Our Ref: BE/108/19/HH
Your Ref:

Town & Country Planning Act 1990 (as amended)
Town & Country Planning (Development Management Procedure) (England) Order 2015
Application for Planning Permission for Works or Extension to a Dwelling

Development Single storey rear extension and conversion of roofspace to habitable use, involving demolition of existing conservatory

Location Anderson Cottage Shripney Road Bognor Regis

Drawing: LOCATION & BLOCK PLANS

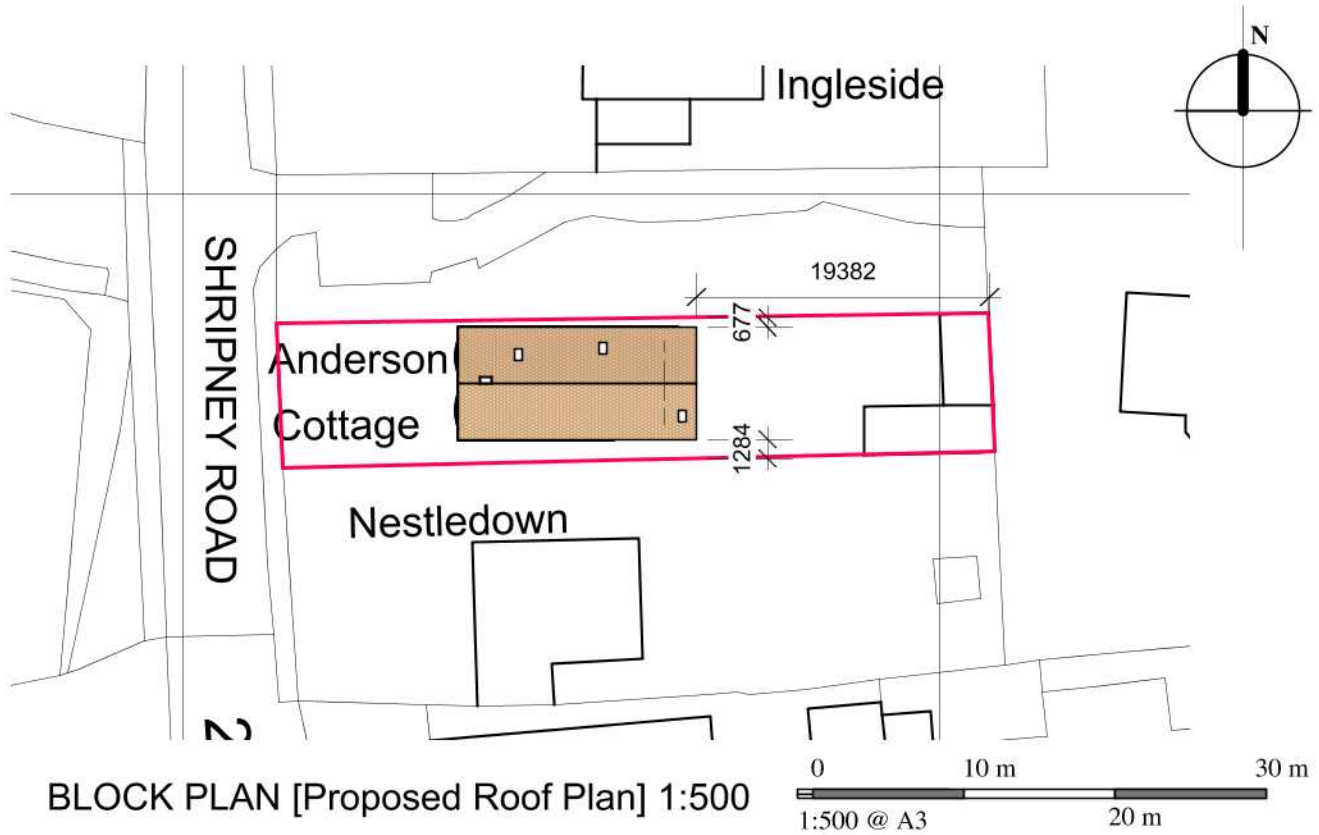
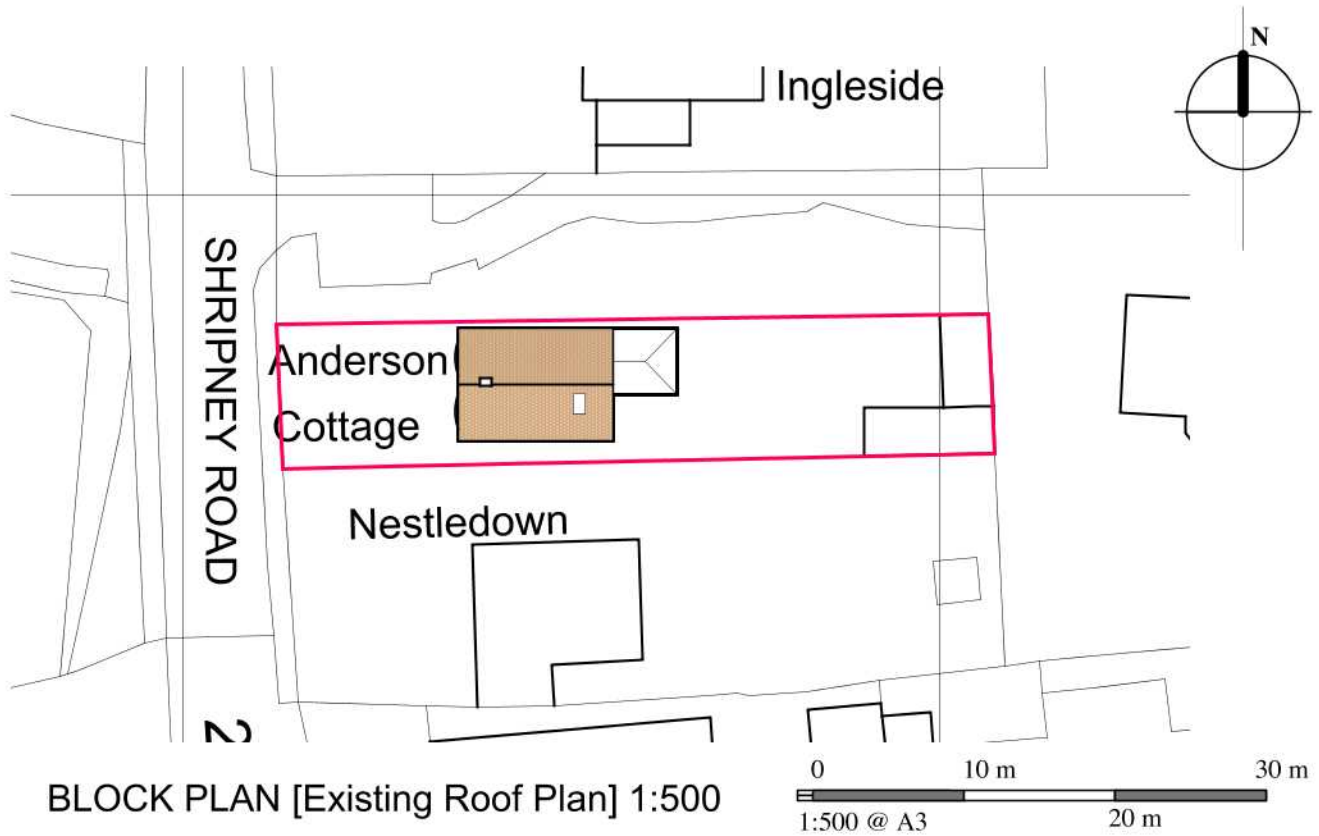
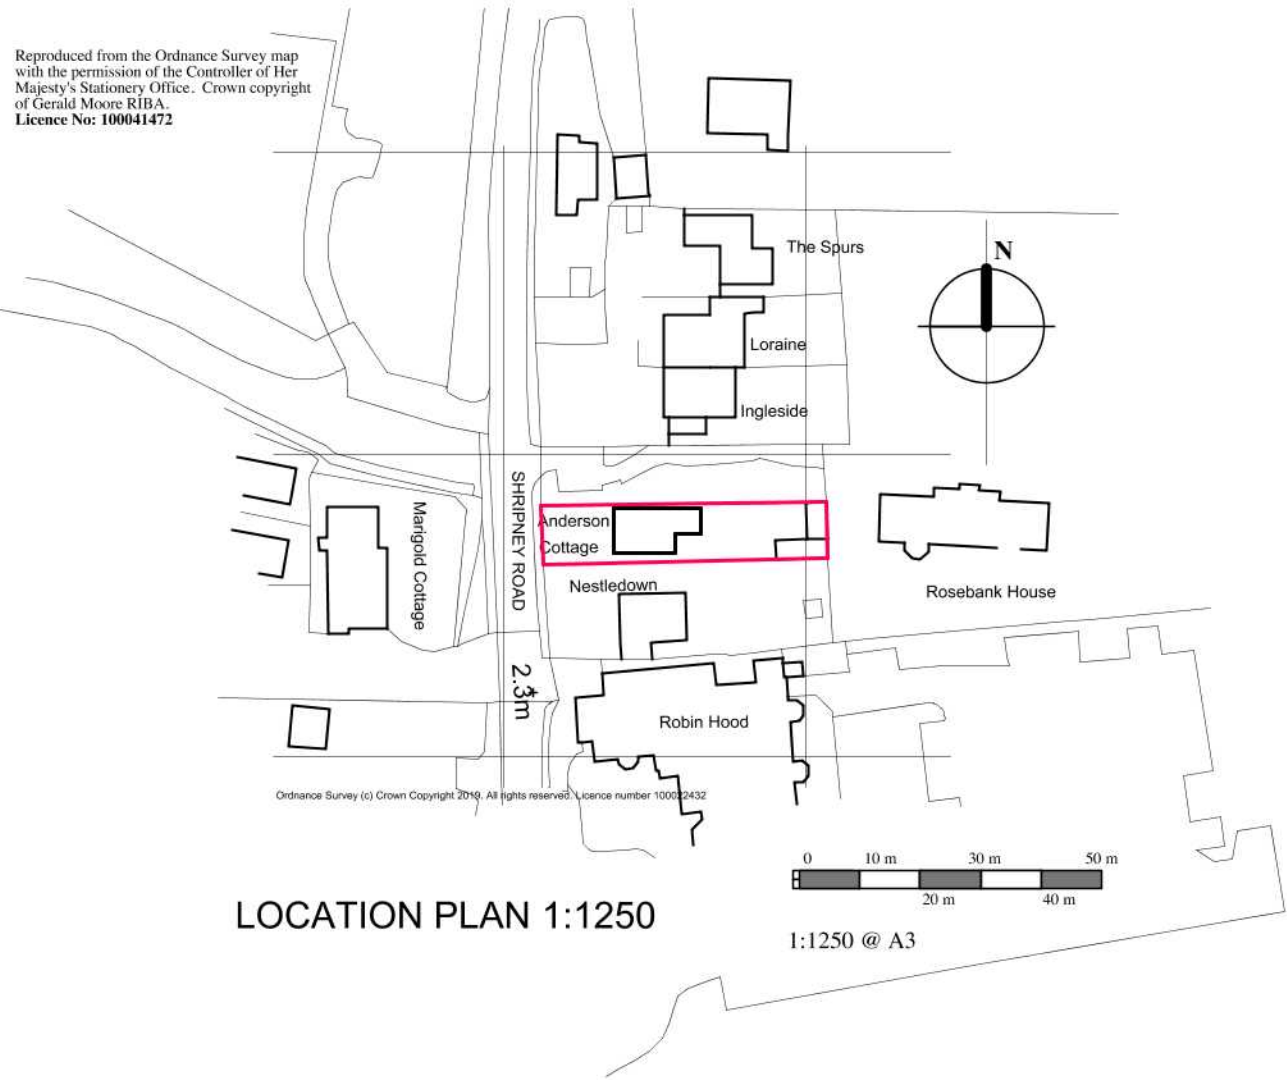
You are required to annotate the dimensions from the proposed extension to all site boundaries.
